SSD 18-9237

YARRABEE SOLAR PROJECT

Response to Submissions Report

Prepared for:
Reach Solar energy

330kV SUBSTATION CONCEPT DESIGN LOCATION AND TYPICAL LAYOUT (SLR Report)

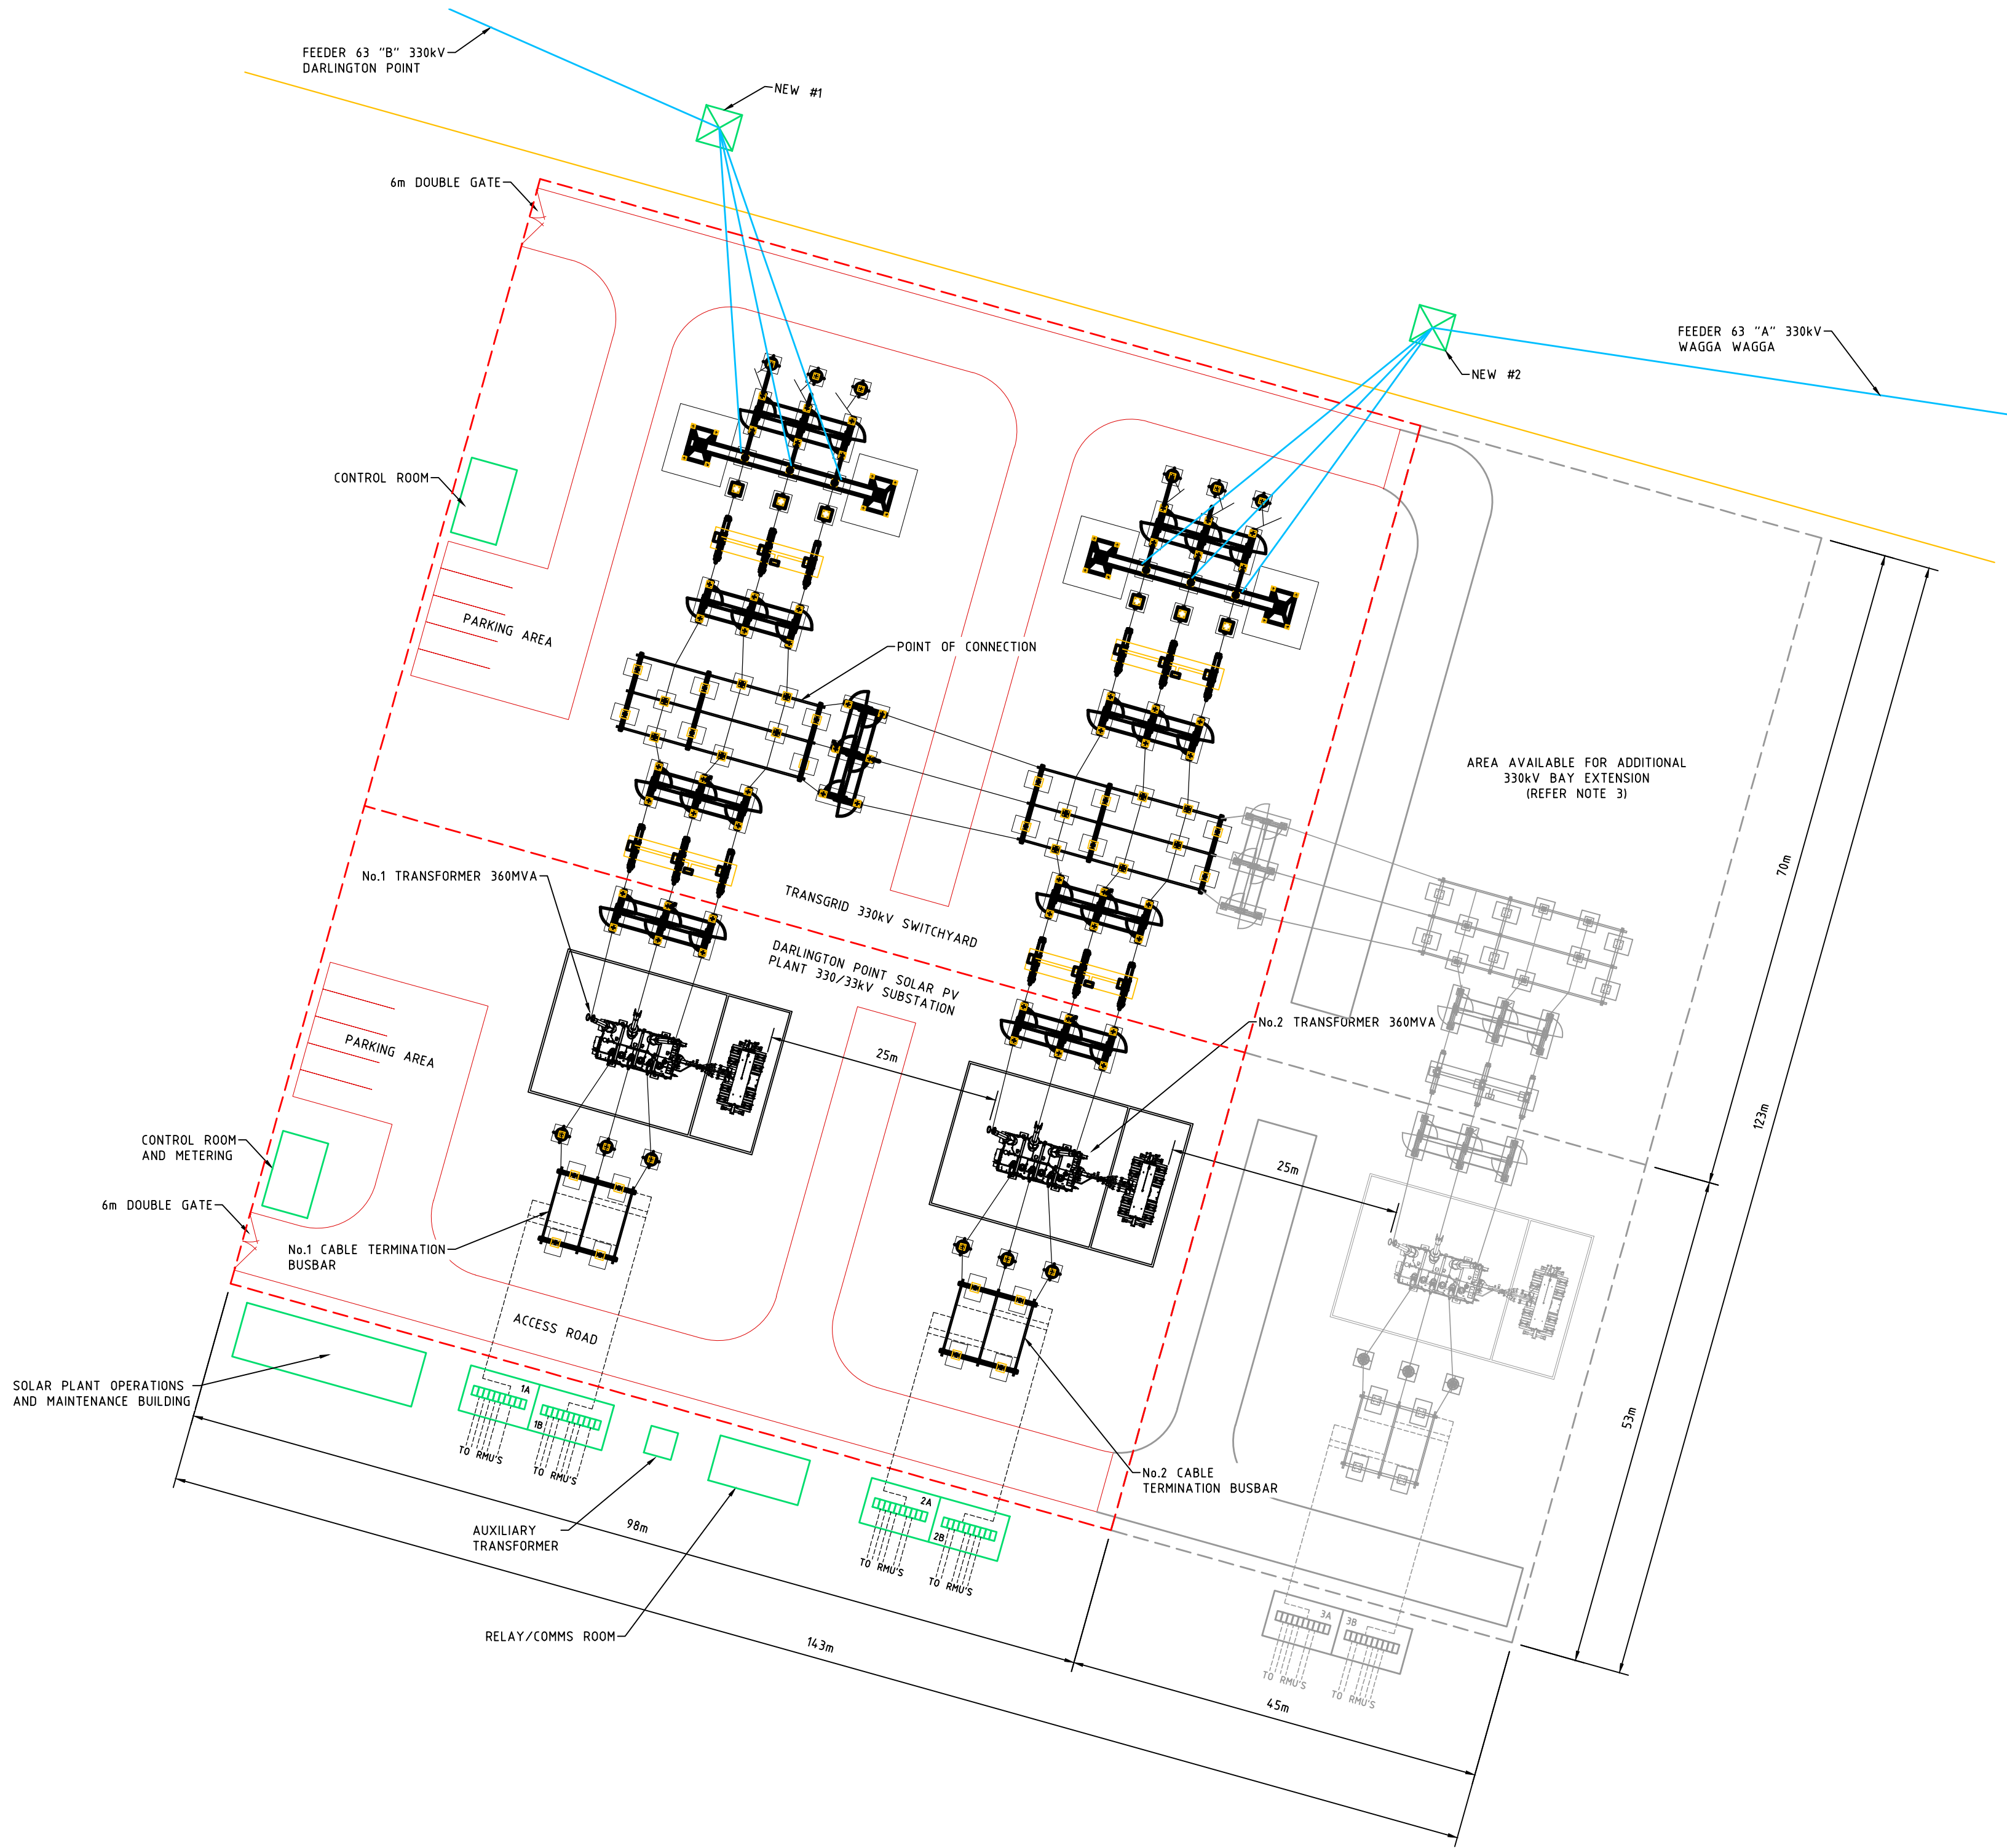
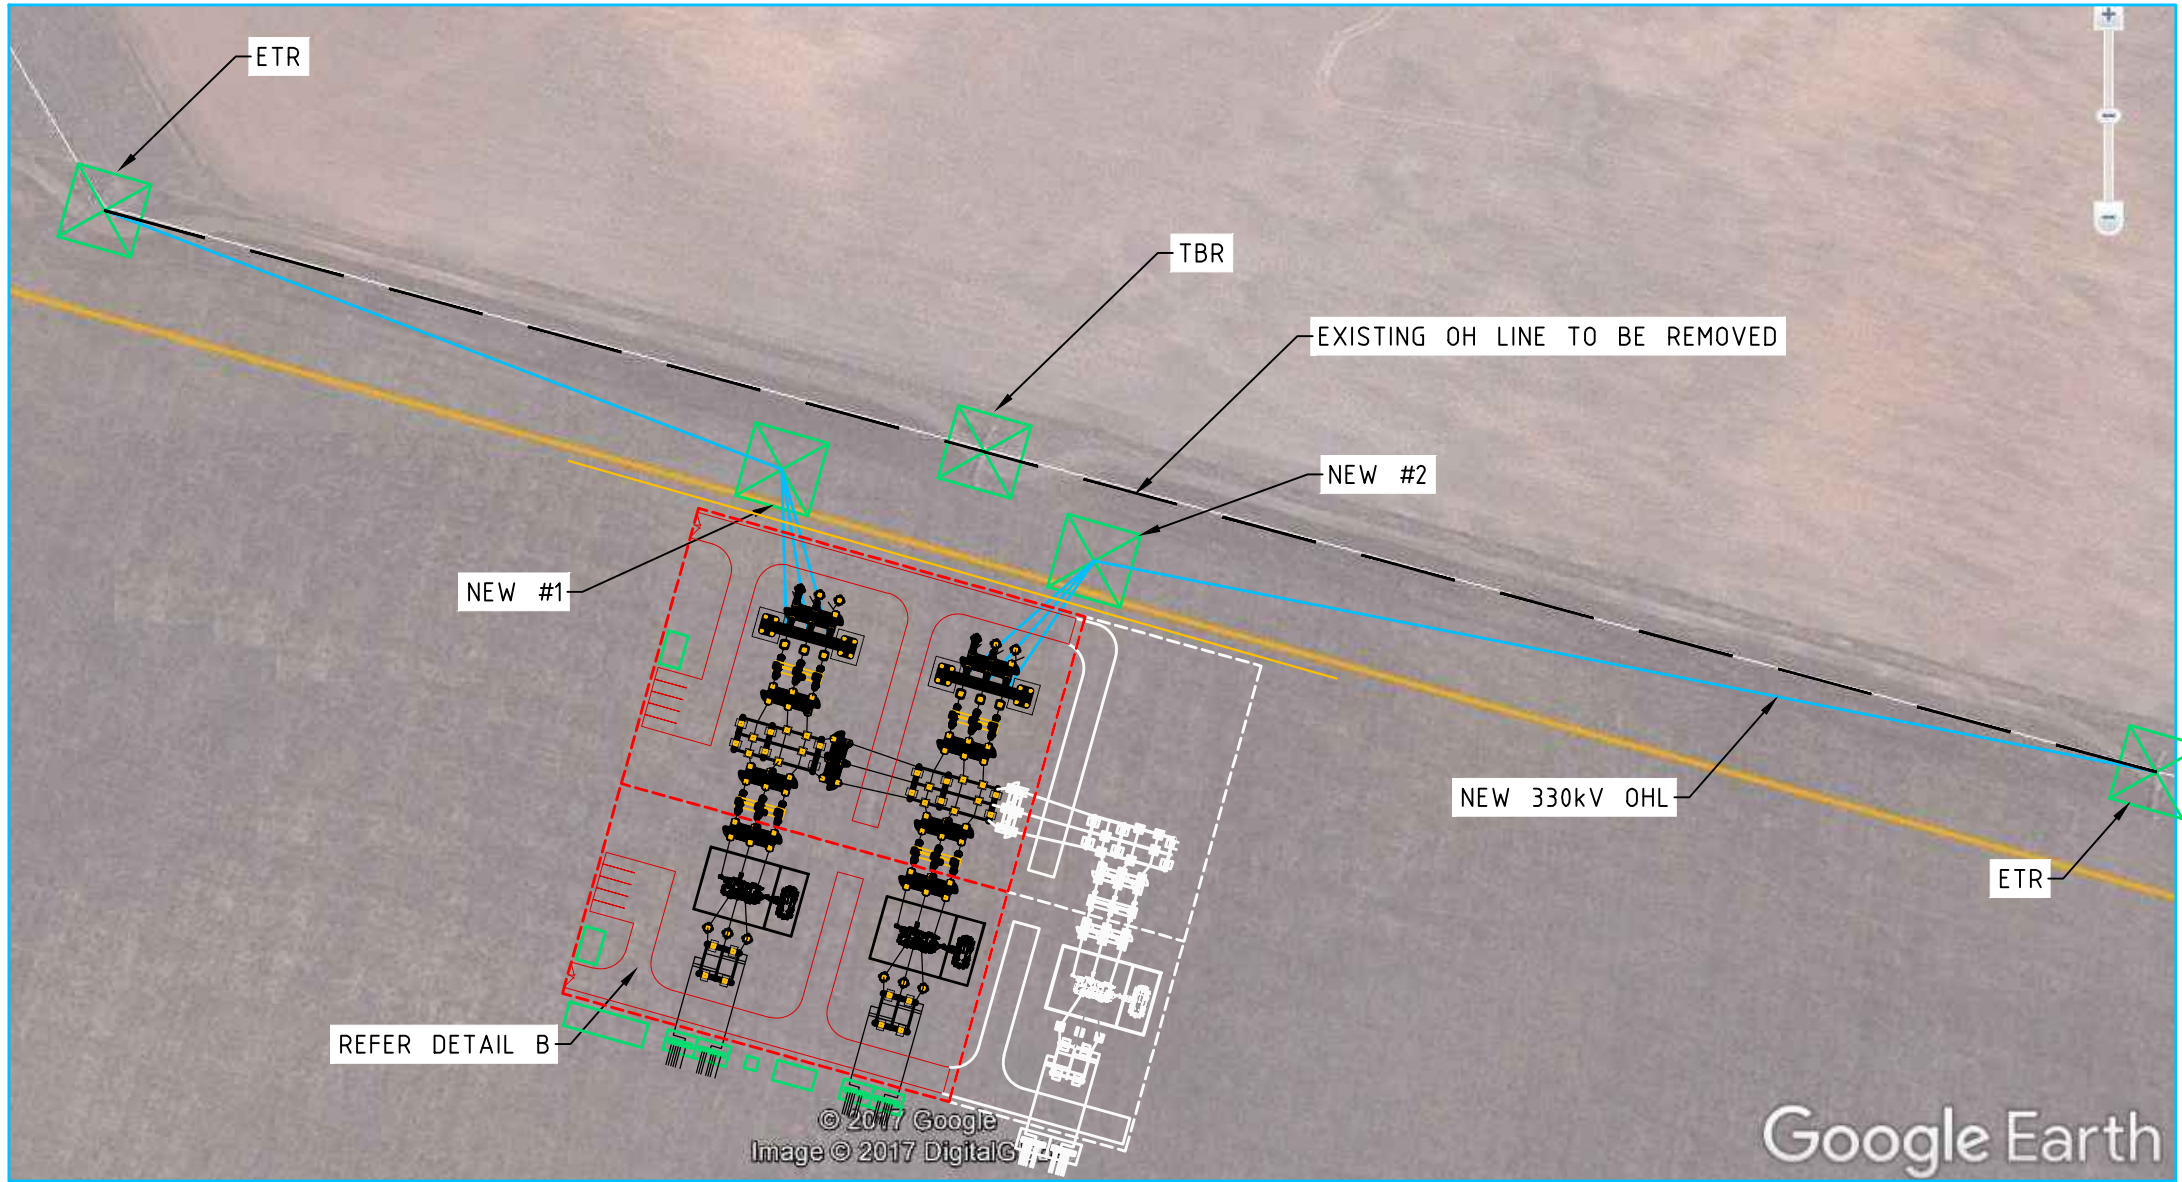
The EIS should identify all land parcels affected by these works and include them within the project boundary – refer EIS **Appendix B**.

Reach Solar have been in discussions with TransGrid as the Transmission Network Service Provider for the Project since its early planning stages. As described in Section 3.4.6 of the EIS, Reach Solar commissioned TransGrid to prepare a feasibility study to identify the ancillary activities required to connect the Project to TransGrid's transmission network. This report was prepared in accordance with the National Electricity Rules and TransGrid's requirements were subsequently included in the scope of the EIS.

Project scope description in the EIS includes ancillary electricity transmission works (i.e. works associated with connection to the National Electricity Market, such as ancillary substation works, transmission line works (direct and upstream), and telecommunications works that would be necessary for the construction and operation of the Project.
